**SSD-45242780 ORANA BATTERY ENERGY STORAGE SYSTEM  
6945 GOOLMA ROAD WUULUMAN**

I refer to your recent correspondence dated 16 May 2023 regarding the proposed Orana Battery Energy Storage System and your request for comments with regard to the exhibited Environmental Impact Statement (EIS) dated March 2023 and prepared by NGH Pty., Ltd.

Figure 3.2: Indicative development footprint and infrastructure layout

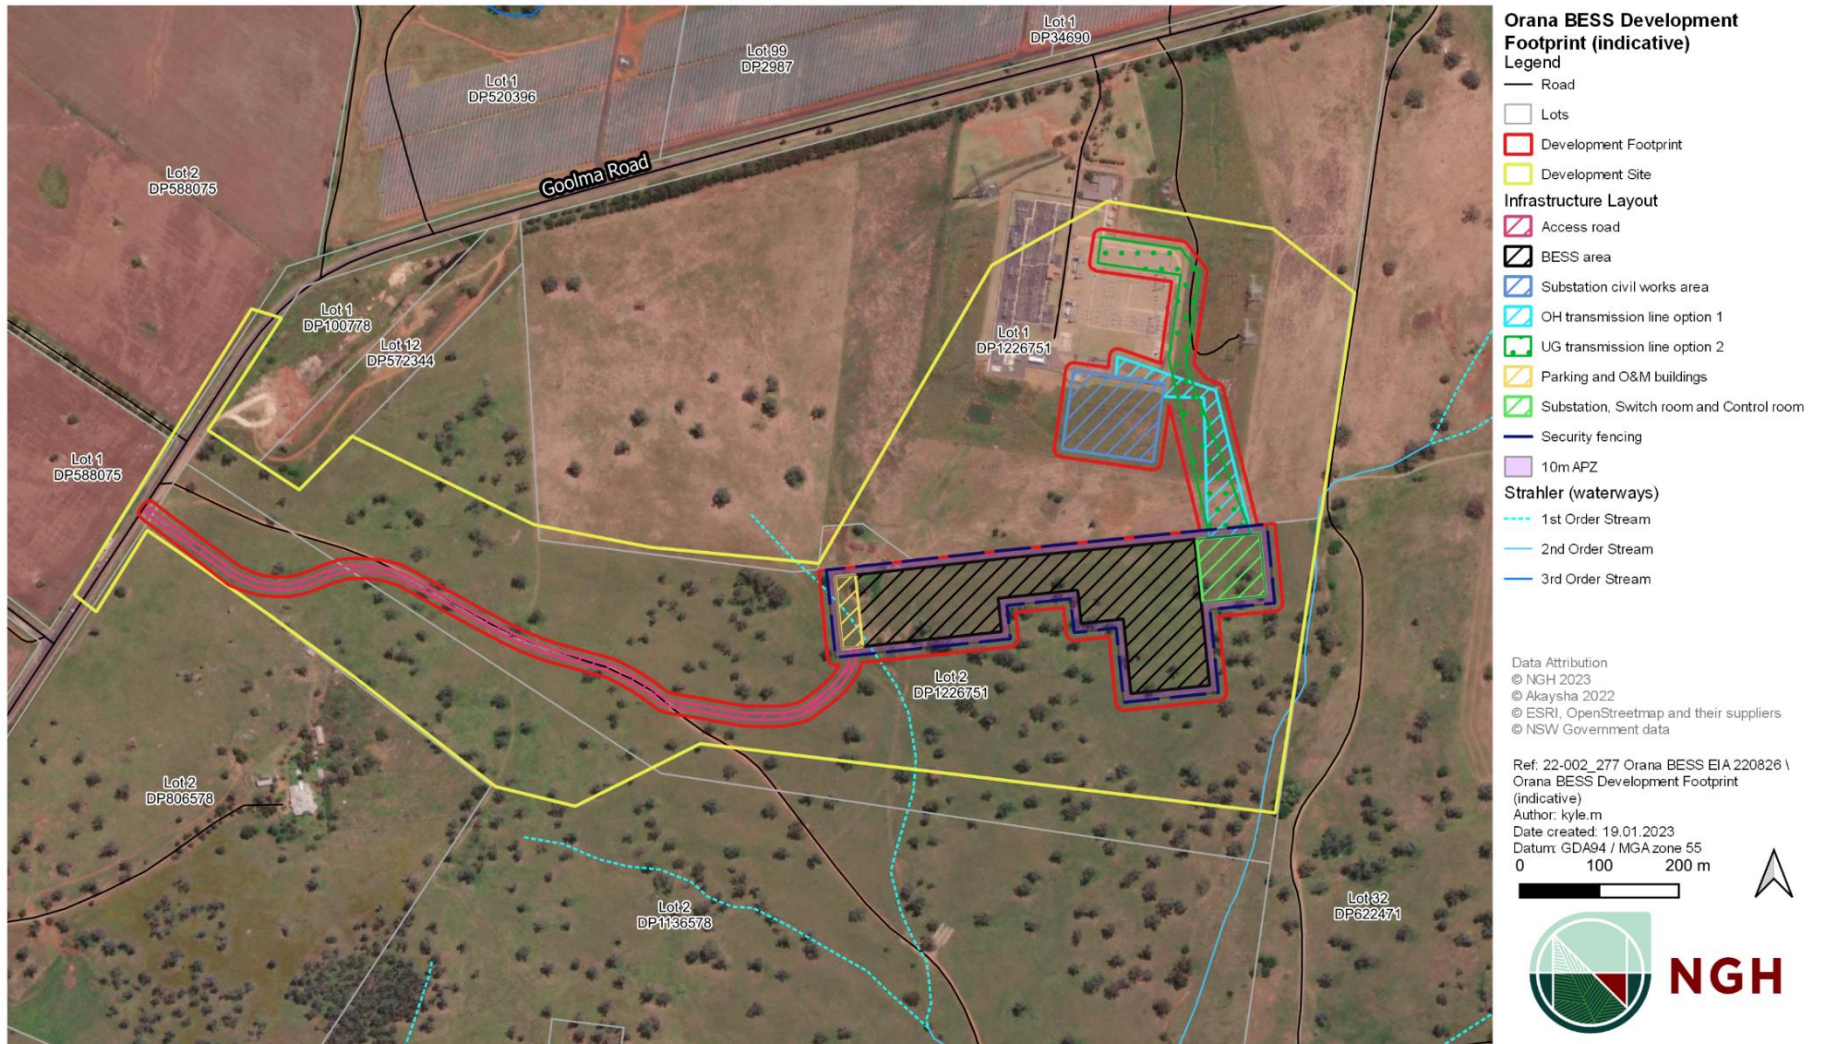
The EIS identifies the areas on which the future Operations/Maintenance and switch/control room buildings will be erected (eg. Figure 3.2, page 35). No indication of the likely size and bulk of such permanent structures are provided in the EIS.

The EIS specifies that *“Detailed layouts for these areas would be developed post-approval and would include suitable means of egress in the event of an emergency.”* (page 137). Concern is raised when the expected size, footprint and bulk is not known, as to how the environmental impacts can be assessed.

APPENDIX 3:
INDICATIVE SUBDIVISION PLAN

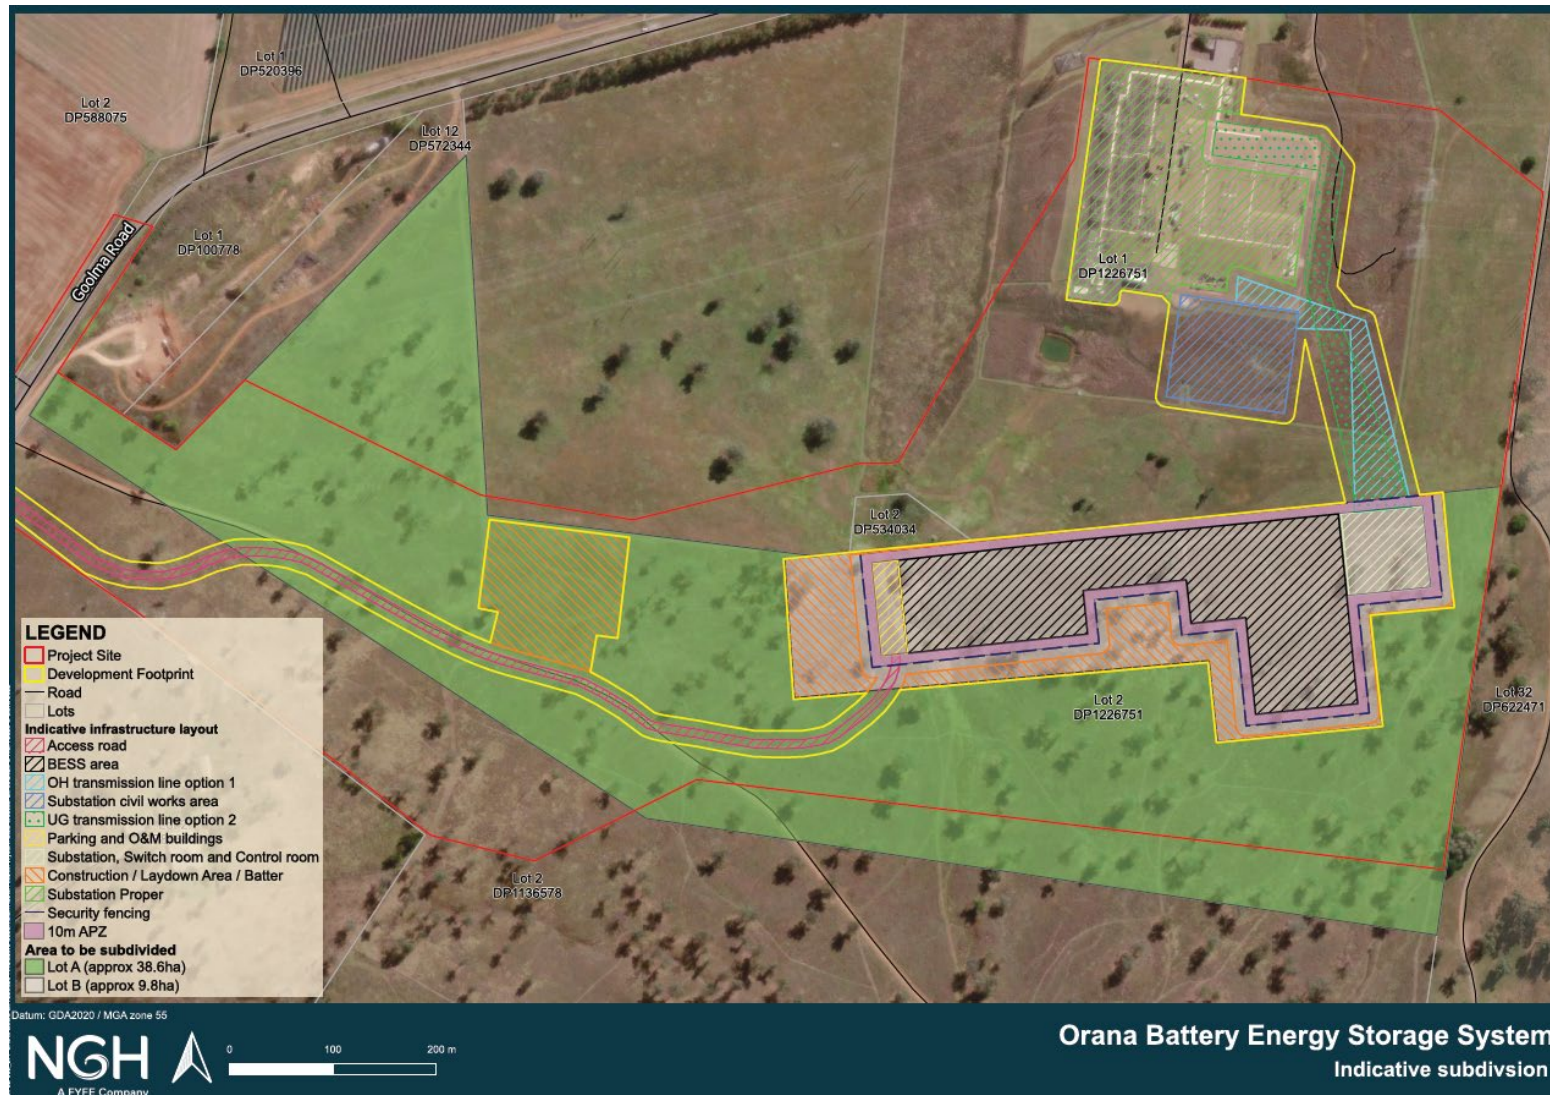
Figure 3-8 provides an indicative subdivision layout. However, there is no reference to the required Asset Protection Zone (APZ) for bushfire protection, which will need to be contained wholly within its boundaries and not located on adjoining allotments.

To assist Council processing a future Subdivision Certificate, the subdivision should form part of the consent, with relevant conditions imposed.
